REFERENCE: Arborist Response to City Review Comments RE: SUB22-009 (Cui Preliminary Short Subdivision)

SITE ADDRESS: 4833 90th Ave SE, Mercer Island, WA

DATE: 8/9/2023

TREE RETENTION CALCULATIONS	
TOTAL VIABLE TREES	22 TREES
TOTAL RETAINED TREES	10 TREES
TOTAL TREE RETENTION	45%

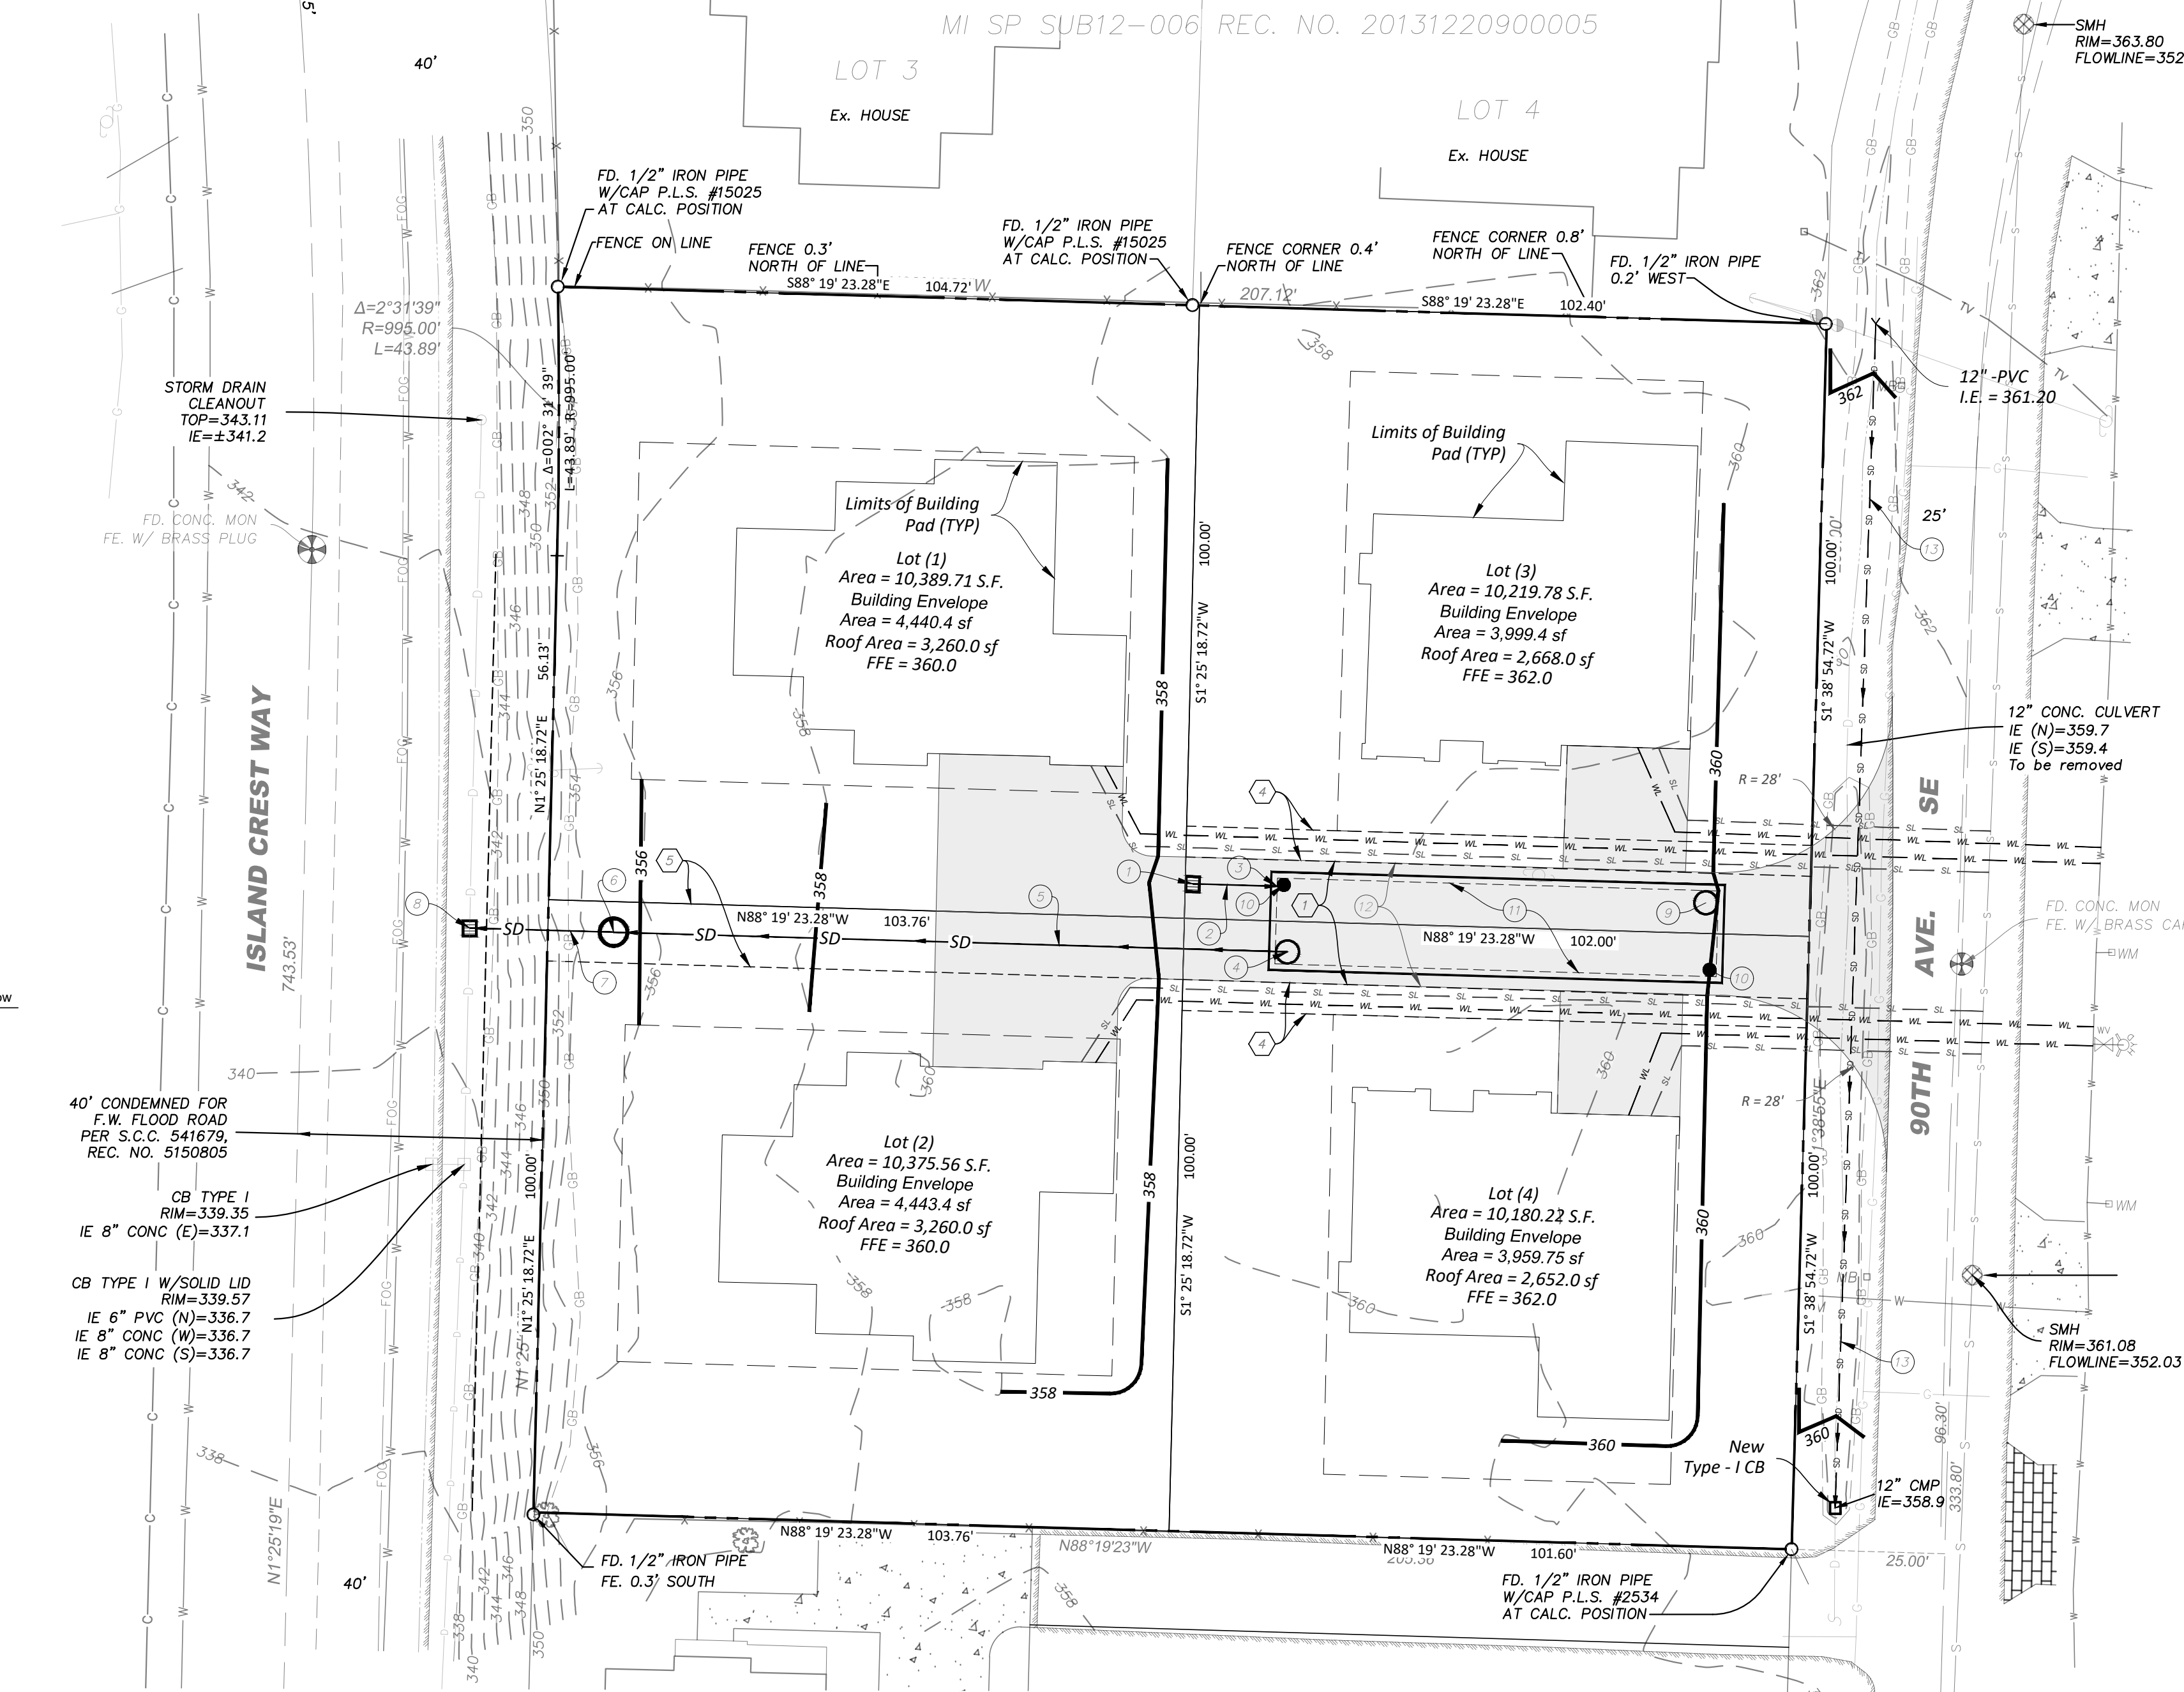
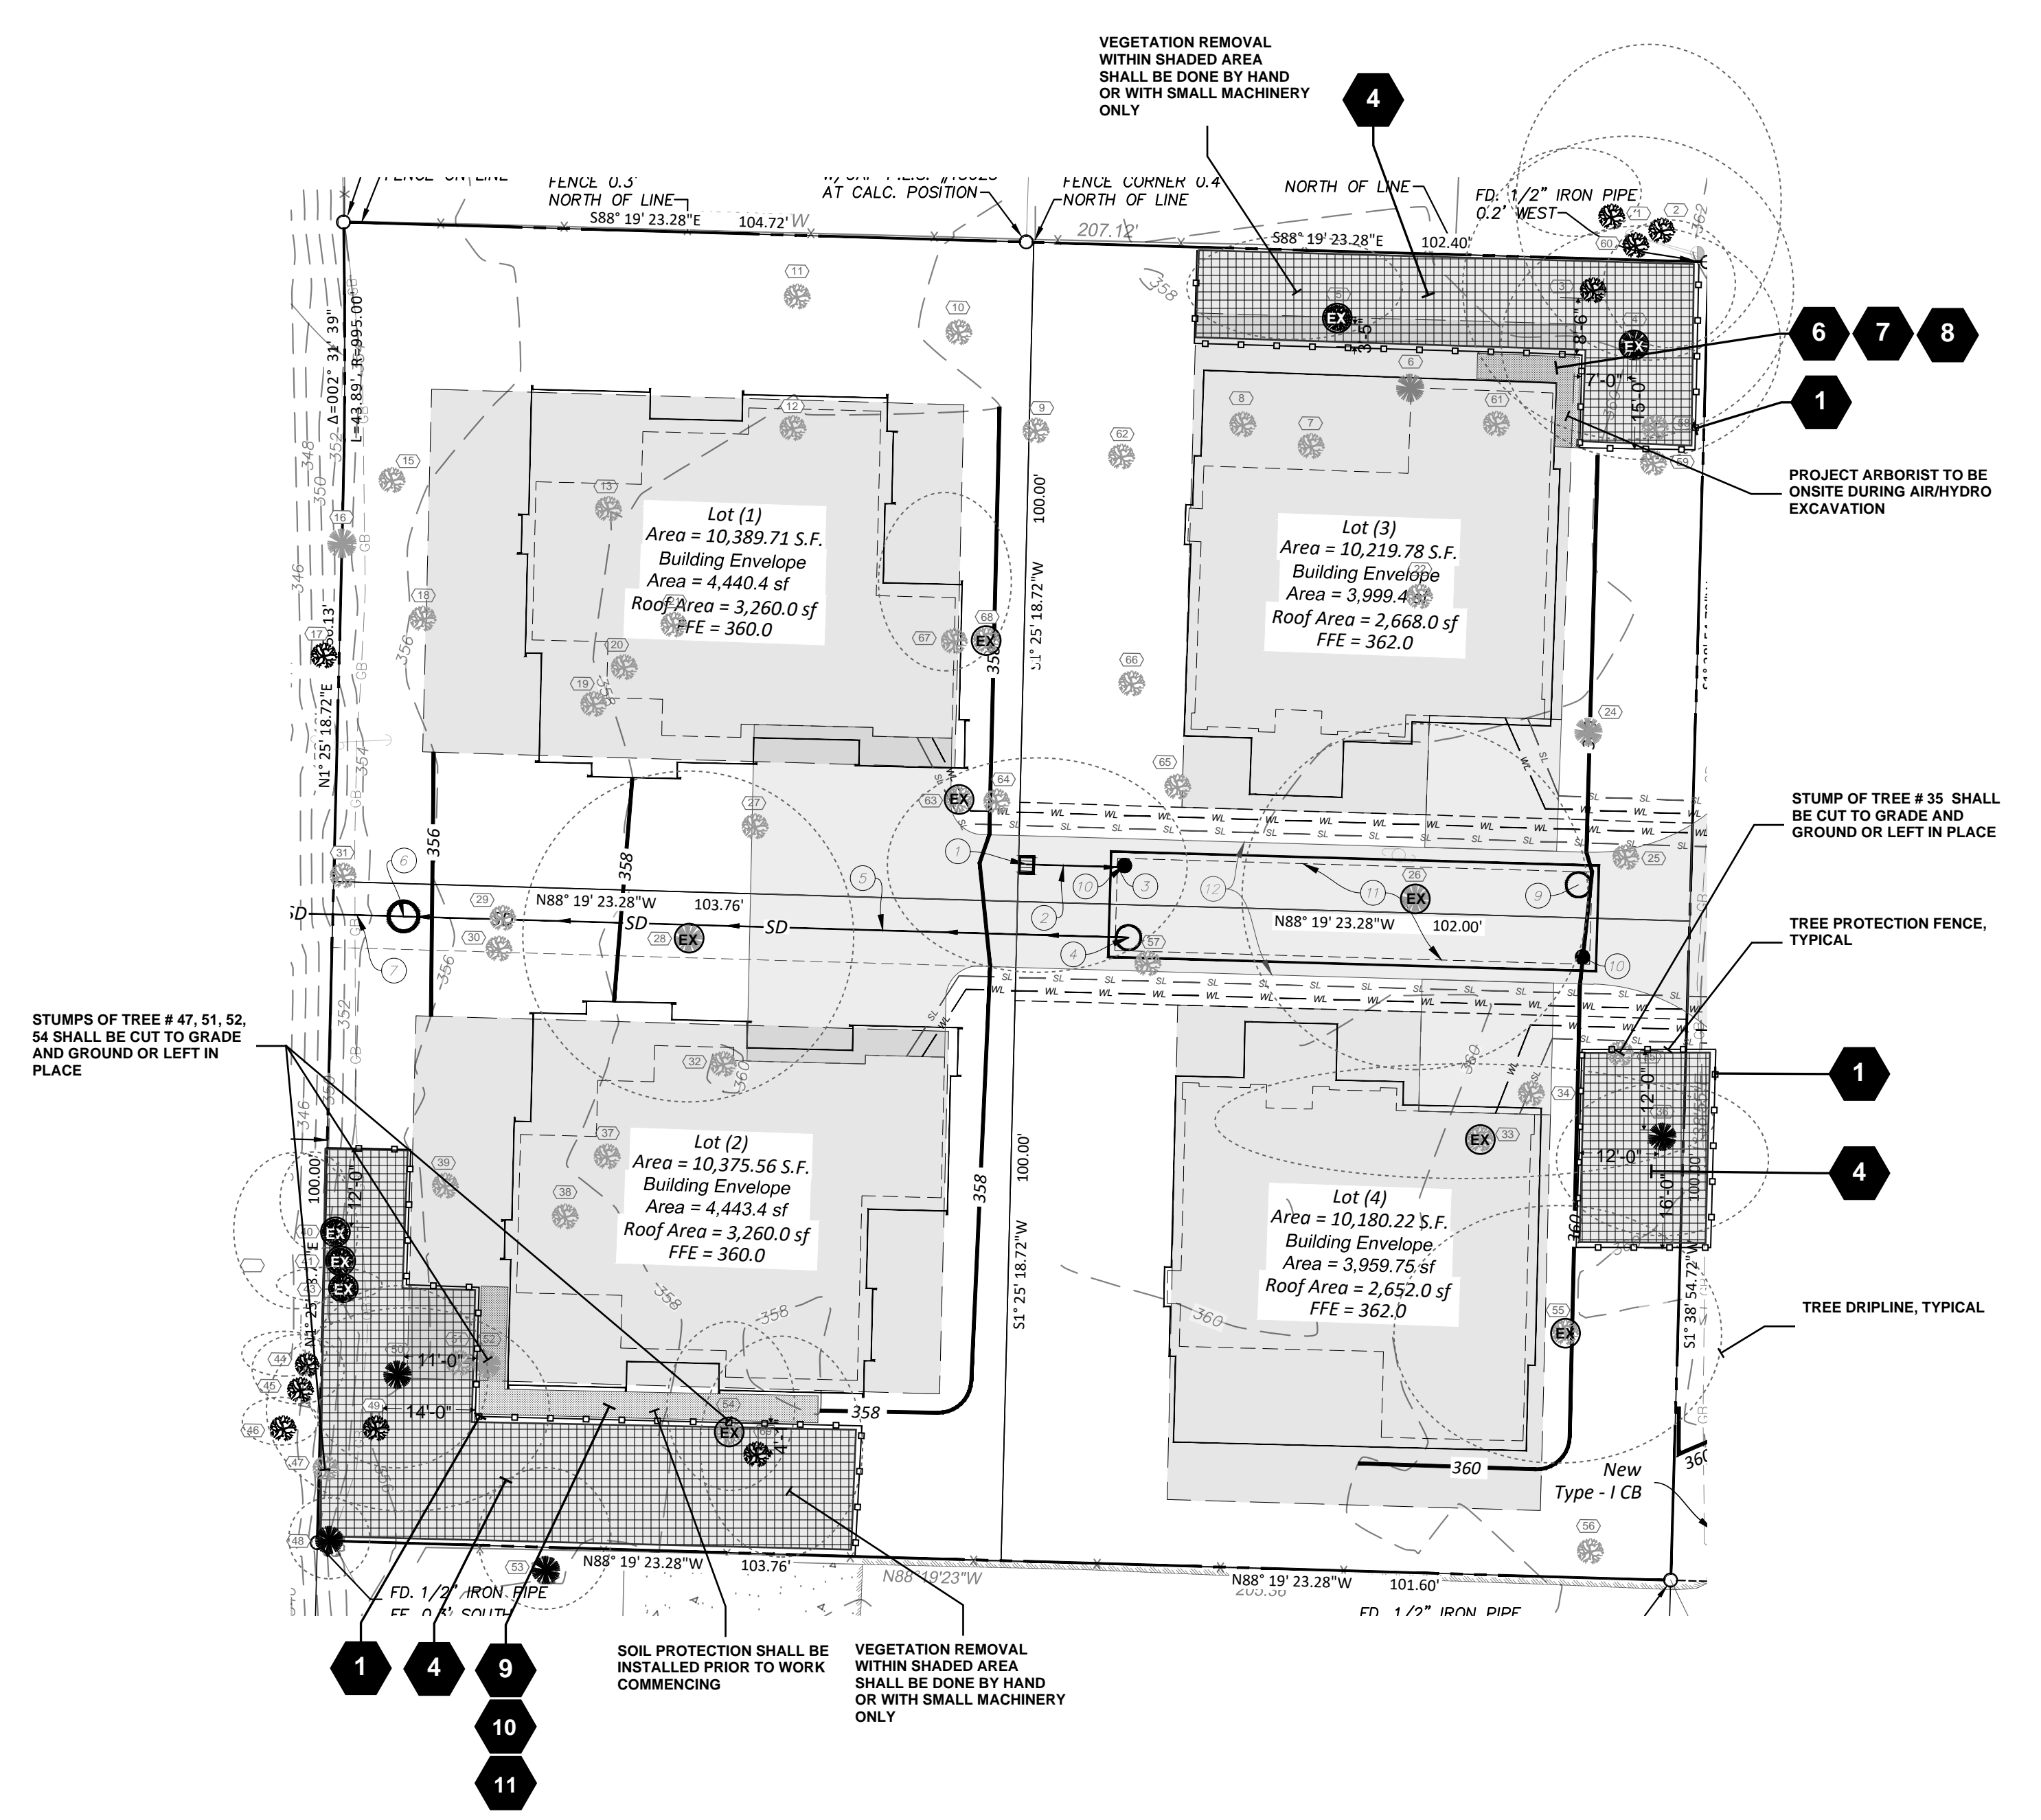
7. *The following trees are shown as retained but not protected at their dripline: 3, 4, 5, 9, 10, 11, 23, 36, 56, 62, 65, 66, and 69. All retained trees must be protected under MICC 19.10.080 in such a way that they will not be damaged and will remain viable long term. The project arborist must address this code section when encroachment into driplines is proposed. The trees would be considered removed because of root damage. Please update the Tree Submittal Checklist according to MICC*

19.10.090. After the limits of allowable disturbance are determined by the project arborist, these limits must be included on the tree protection plan. Any excavation within the driplines of exceptional trees or other trees required to be retained must be concluded not to damage the trees. This will require advanced root analysis and excavation under arborist supervision. The limits of allowable disturbance must be confirmed to locate the building pads. A preliminary civil plan with access and utilities should be created to confirm trees proposed for retention can indeed be protected.

- a. **Response: 10 viable trees are proposed for retention on the site (#s 3, 4, 5, 36, 40, 41, 43, 49, 50, 69). Please refer to the table below, Tree Retention Plan, and Arborist Report titled “Arborist-Report_4833-90th-Ave-SE_08.04.2023” for complete tree protection specifications and recommendations.**
